MEMO

ALDINGBOURNE FARM SHOP, NYTON ROAD, ALDINGBOURNE – AL/9/11/DOC

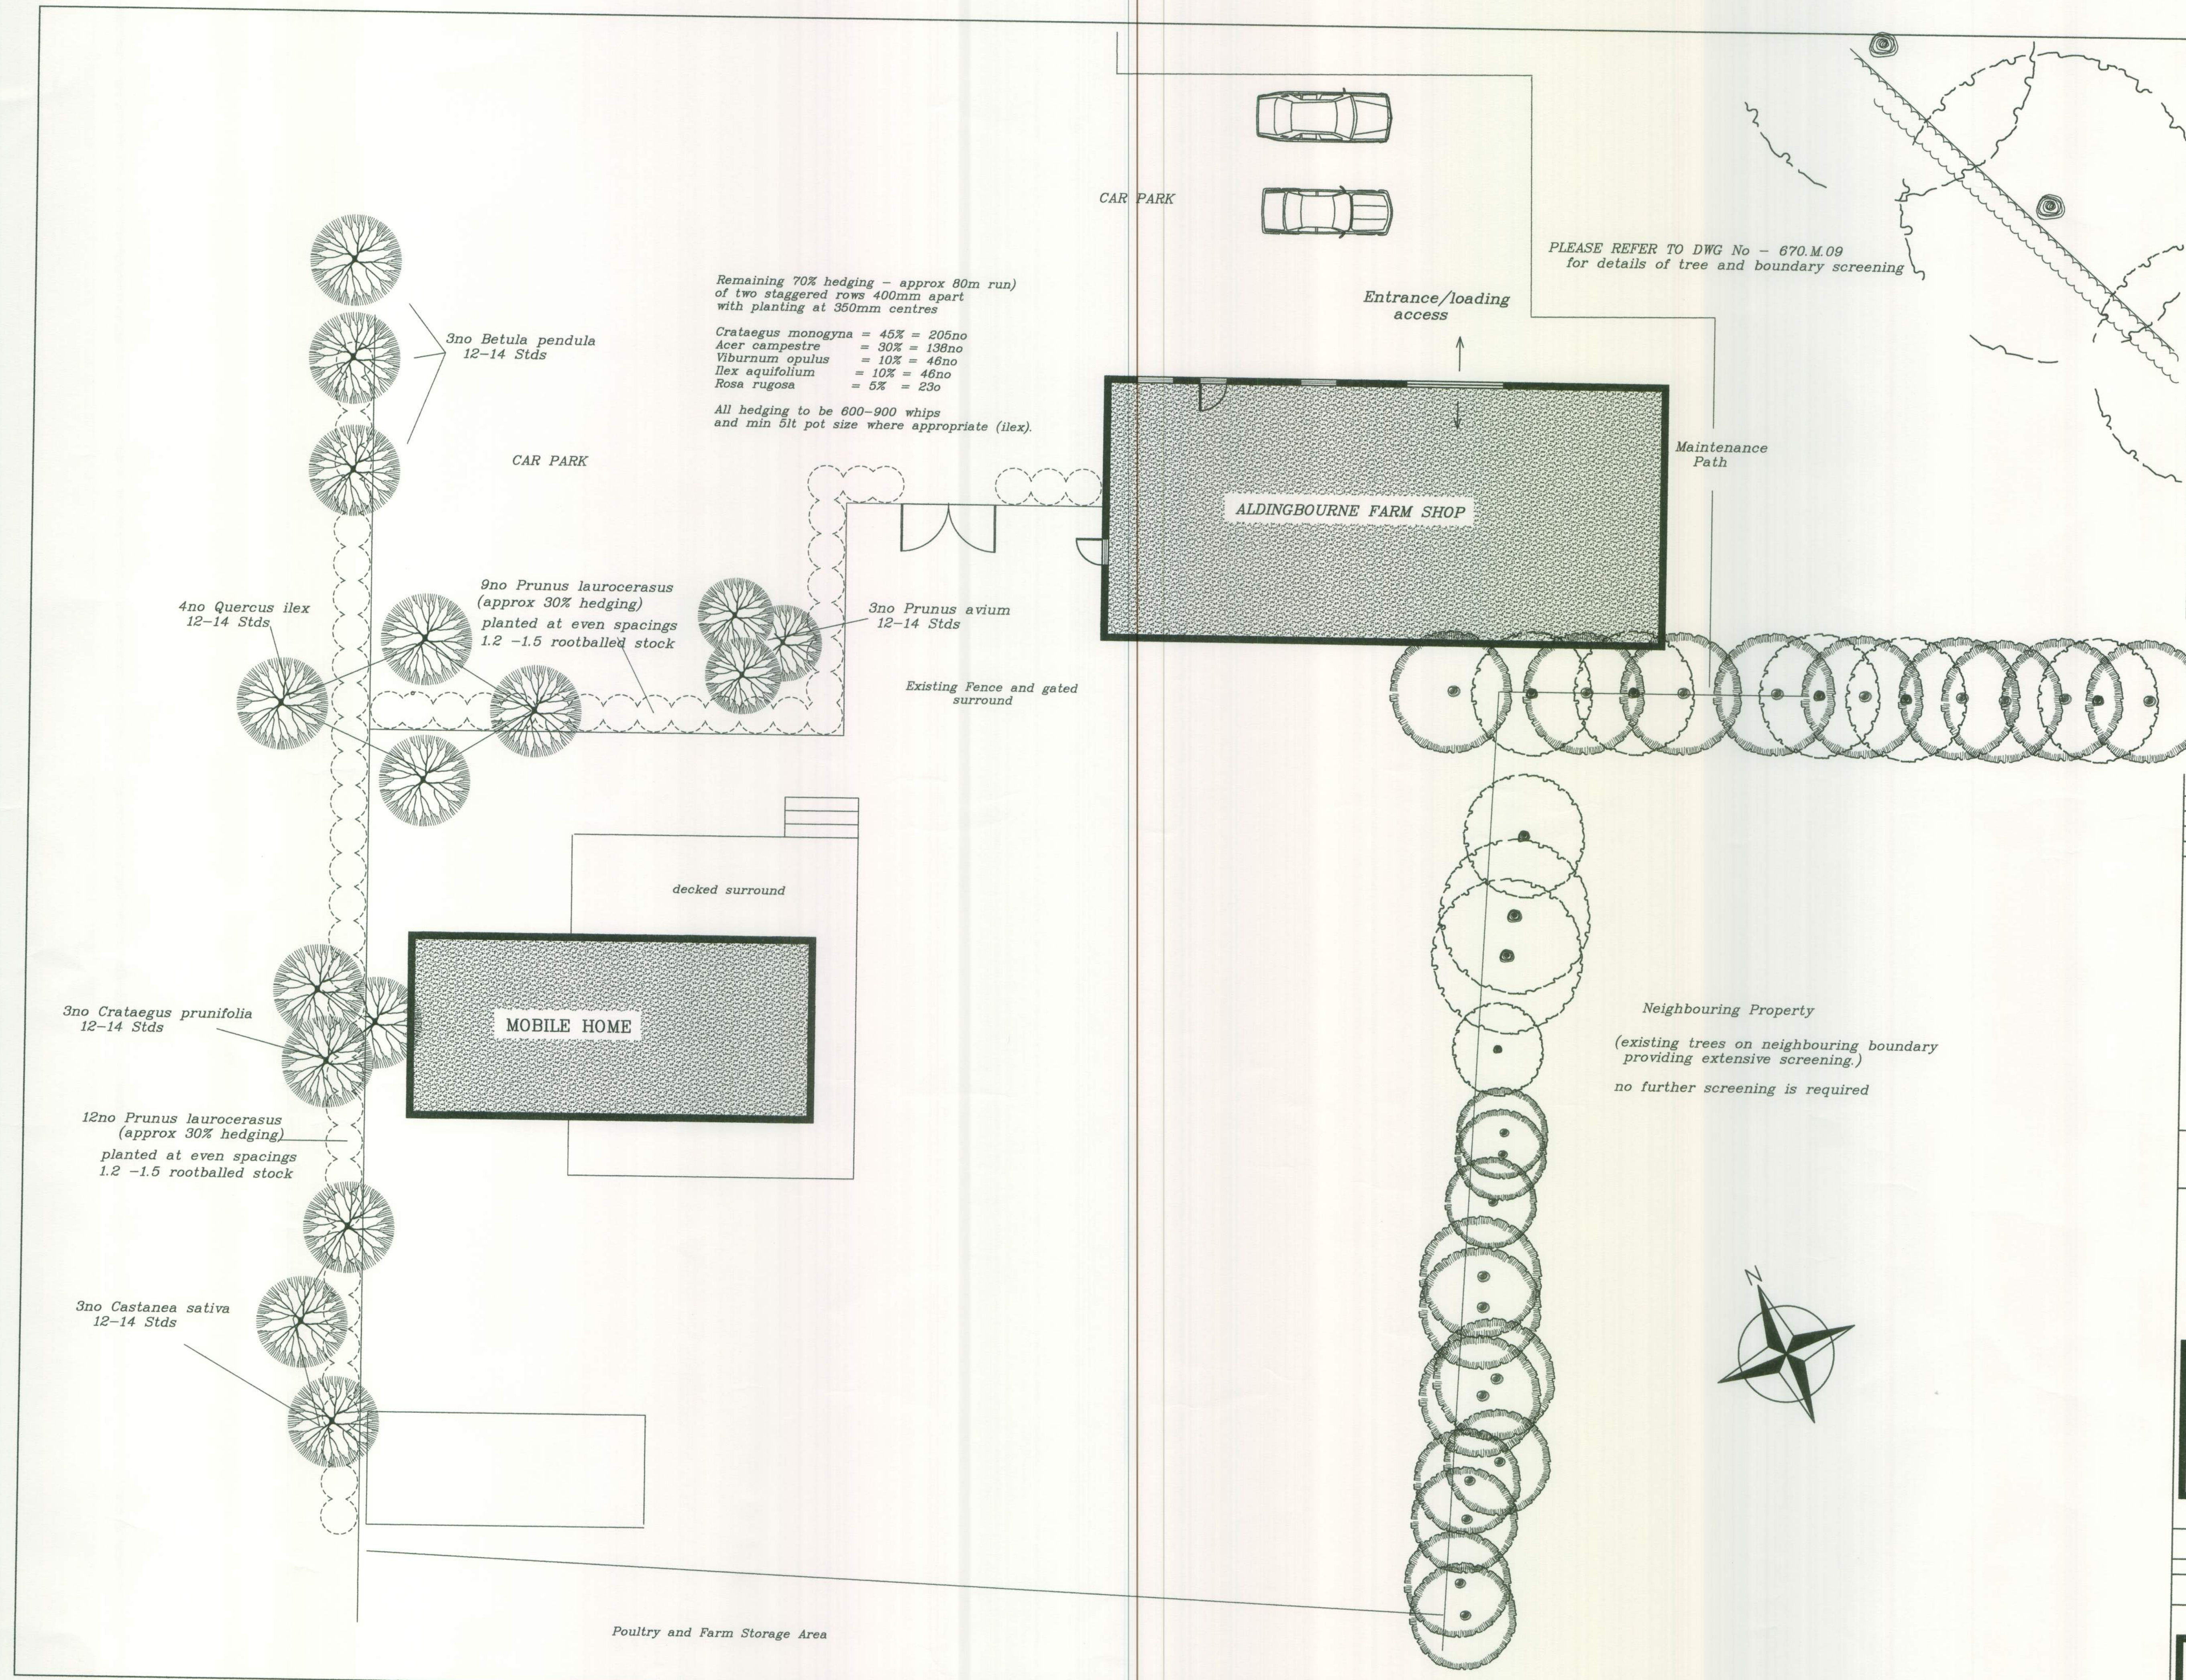
The revised landscape plan submitted has a reduced quantity of cherry laurel and introduced a good percentage of native hedge mix. The planting will form an effective screen to the site and is appropriate to the rural setting. I therefore recommend that the plan is approved.
